From: Thomas Callaway
Sent: 28 August 2015 15:45
To: Planning.Responses
Subject: RE: Planning Consultation on: AL/67/15/HH

APPLICATION **AL/67/15/HH**

Site Address: 58 Olivers Meadow Westergate PO20 3YA

Description of Works: Garden shed to rear & conversion of garage into habitable space.

GARDEN SHED ELEVATIONS. 1:50.

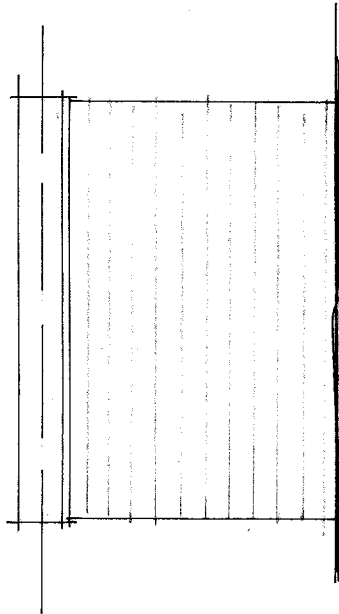
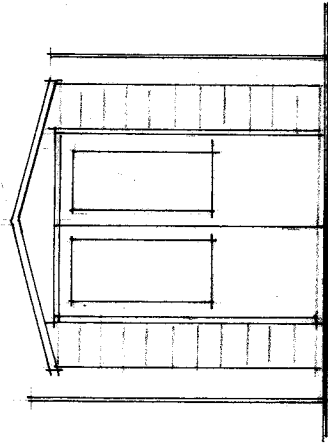
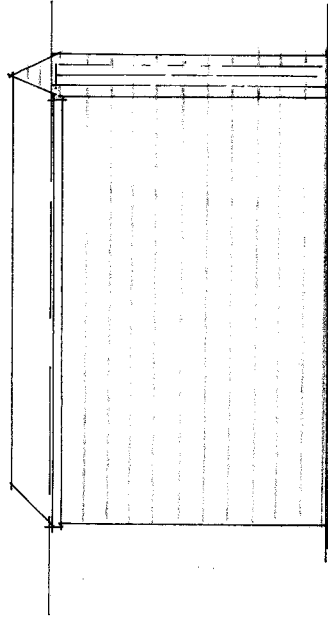
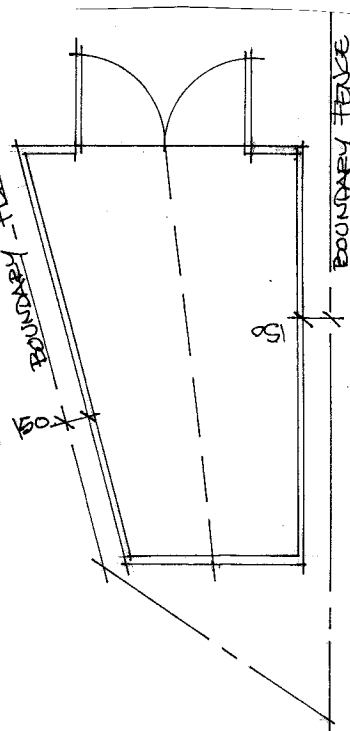
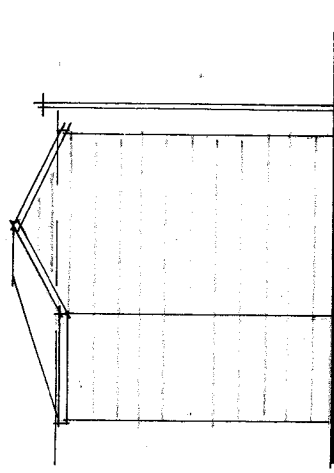
Soakaways should be investigated for all new roof area.

Infiltration rates for soakage structures are to be based on percolation tests undertaken in the winter period and at the location and depth of the proposed structures. The percolation tests must be carried out in accordance with BRE 365, CIRIA R156 or a similar approved method and cater for the 1 in 10 year storm between the invert of the entry pipe to the soakaway, and the base of the structure. It must also have provision to ensure that there is capacity in the system to contain below ground level the 1 in 100 year event plus 30% on stored volumes, as an allowance for climate change. Adequate freeboard must be provided between the base of the soakaway structure and the highest recorded annual groundwater level identified in that location.

Any SuDS or soakaway design must include adequate groundwater monitoring data to determine the highest winter groundwater table in support of the design. The applicant is advised to discuss the extent of groundwater monitoring with the Council's Engineers. Supplementary guidance notes are also enclosed for information.

Please apply standard conditions ENGD2A.
